Superior NW Enterprises

August 24, 2023

RE: Review of retaining wall plan for 6950 SE Maker, PN-9350900620

**C-2**

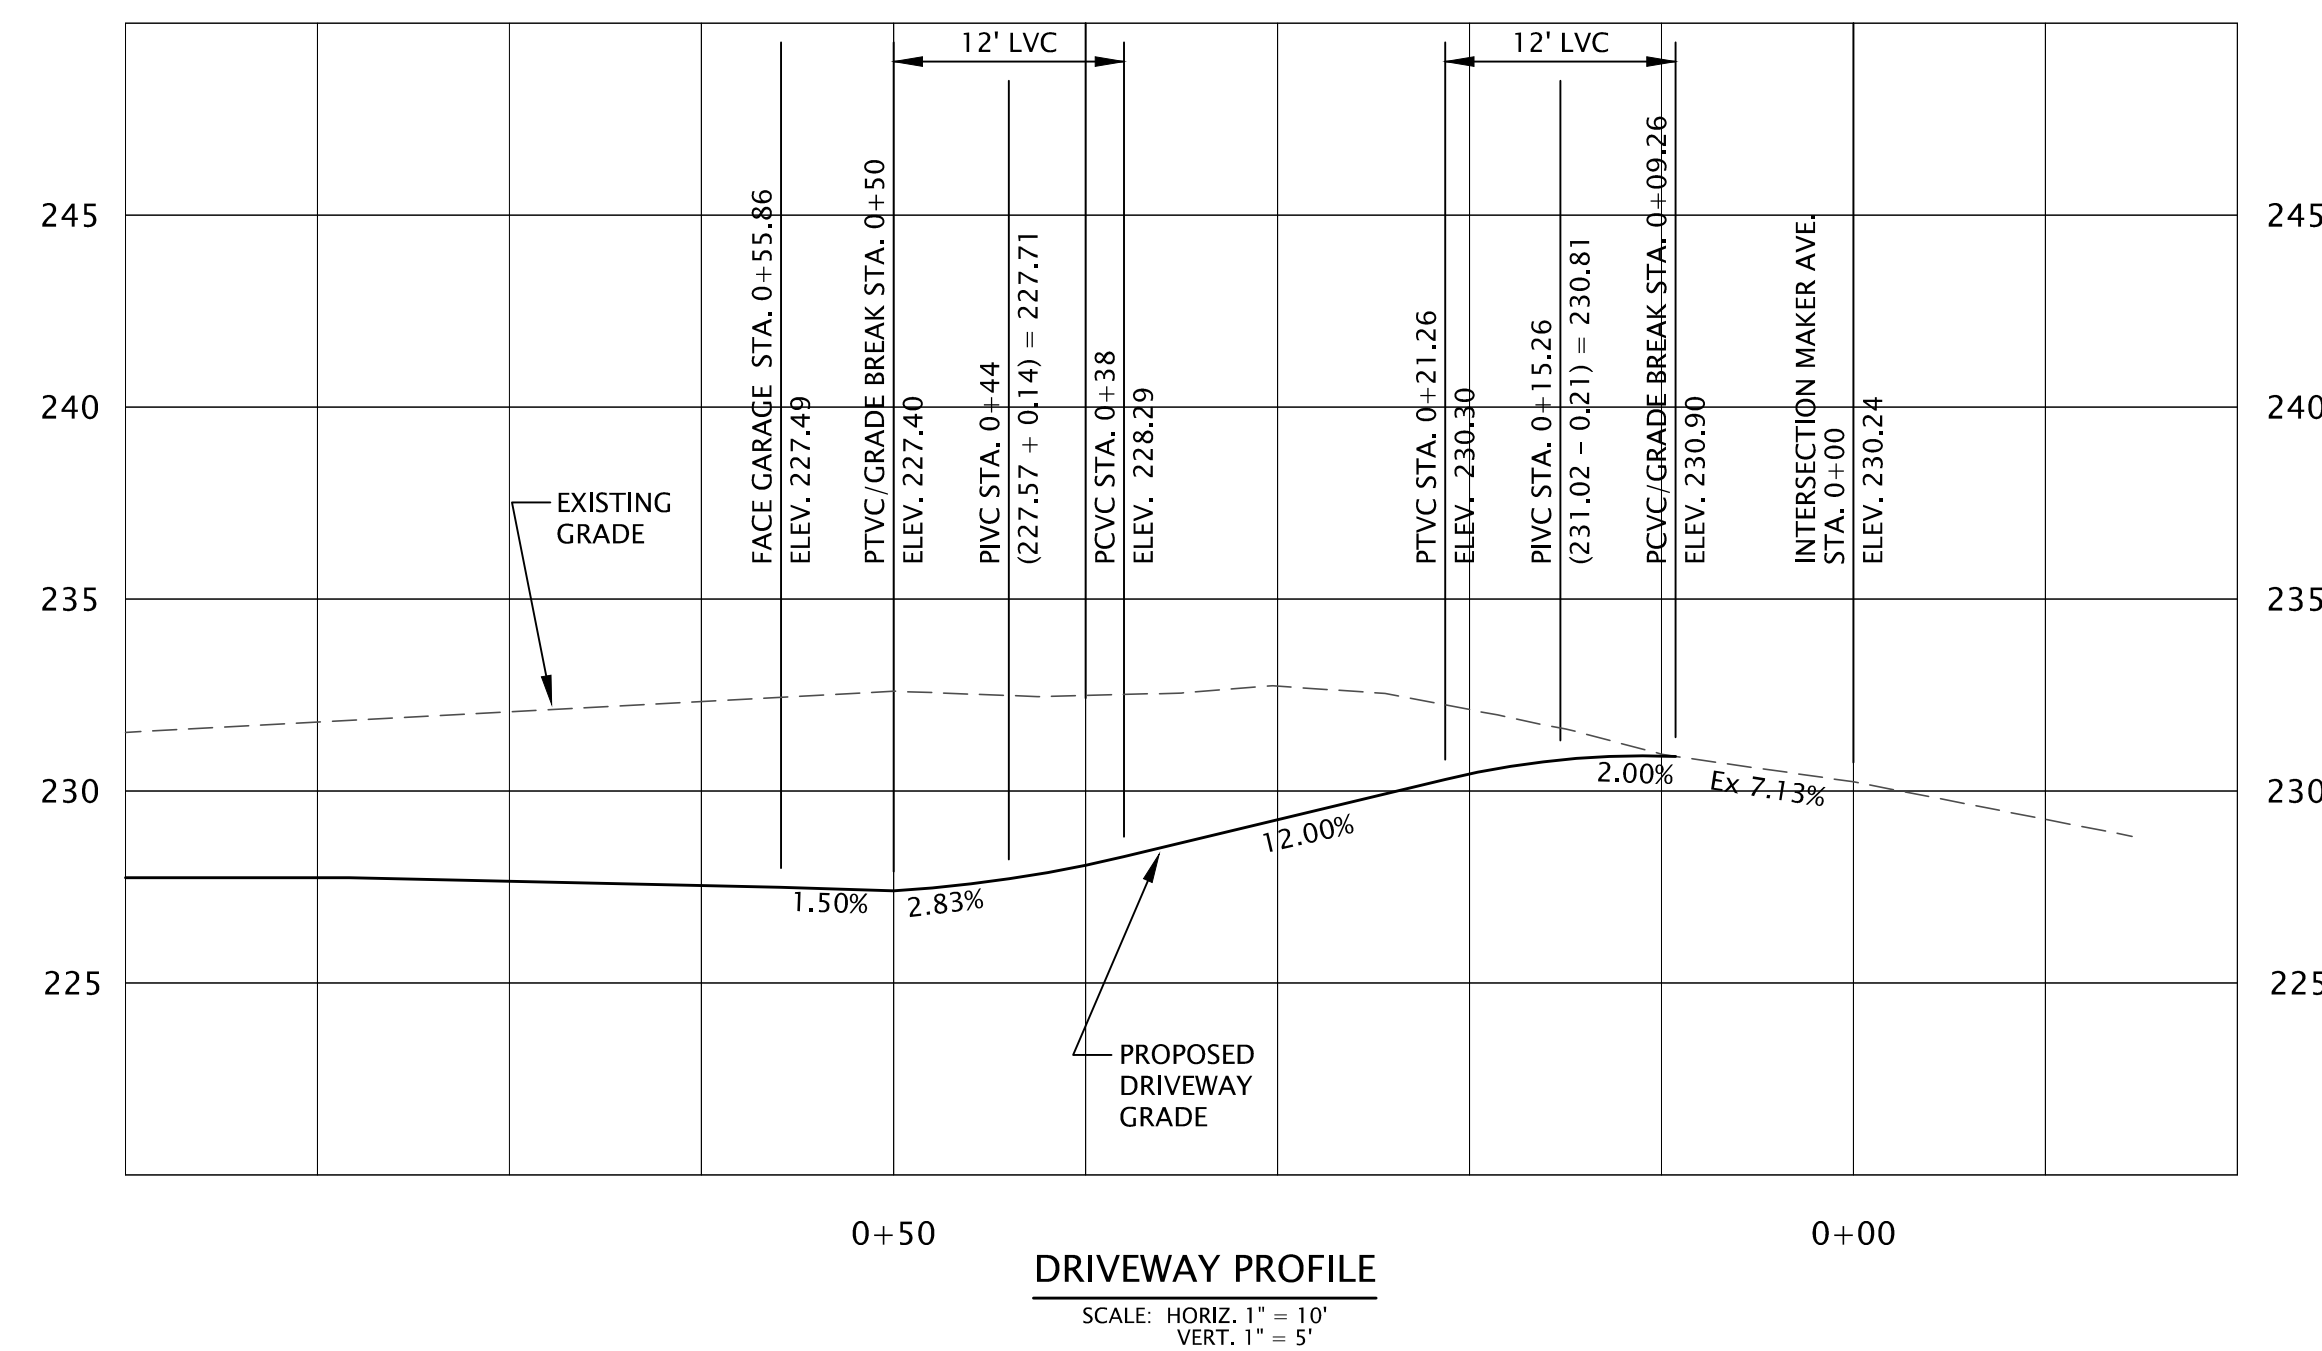
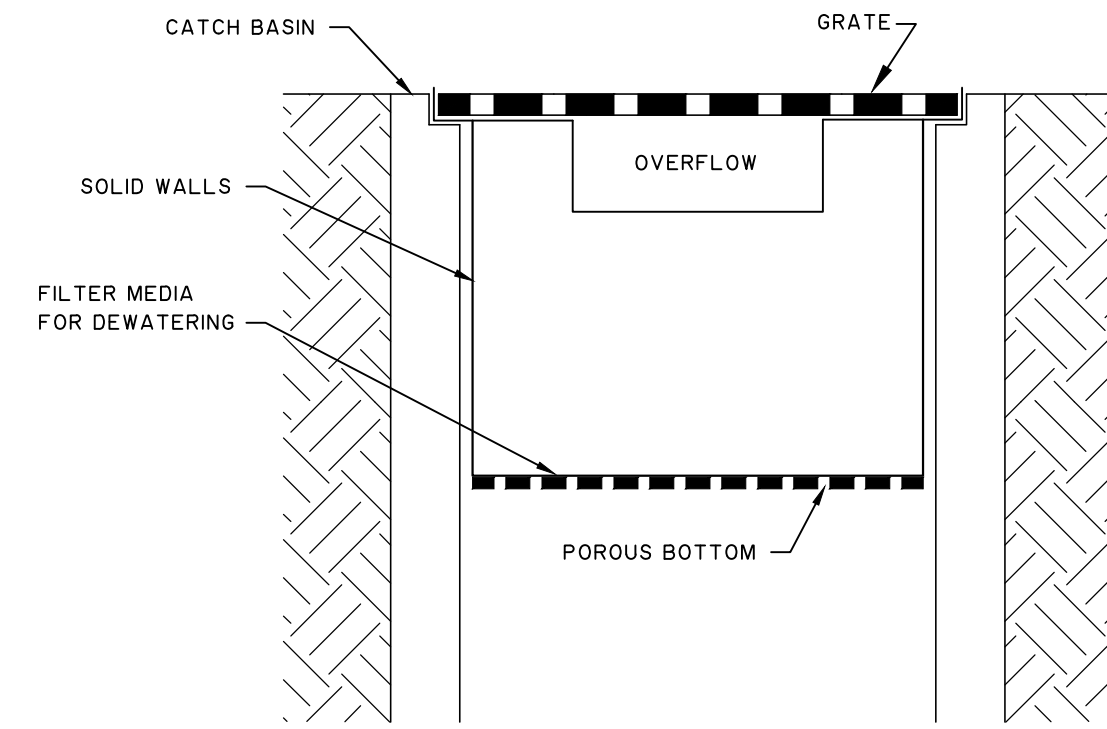
Initially no significant impacts were going to occur near the tree beyond the removal of the existing deck. However a geotech reviewing the proposed plan grew concerned with the exiting rock retaining wall on the west side of the yard. He recommended that a pile and timber retaining system be installed to the east of the existing one. This work will theoretically cross into the CRZ of the big offsite fir.

Based on the plan set drawing shown in Figure 1 the north end of the new wall will terminate 15' out from the base of the tree. This means there is no chance that the work will damage the Structural Root Plate of the tree.

The base of the #4 tree is close to 5' below the level of *the base* of the existing stone wall which ends right at the NW corner post. According to the architect and builder this wall will remain in place and not be disturbed. Only a secondary section of stone that is well outside the theoretical CRZ will be removed to facilitate the installation of the pile wall.

Installing another wall 4-5' E and nearly 5' higher on the grade will create no significant disturbance for the tree. No excavation will be done to the existing grade. There will be fill work done to level the grade but this will occur over only 6% of the tree's theoretical rooting space. Again, it is highly unlikely that the fir does have roots present in the area.

Out of an abundance of caution an arborist should be onsite during the proposed work.
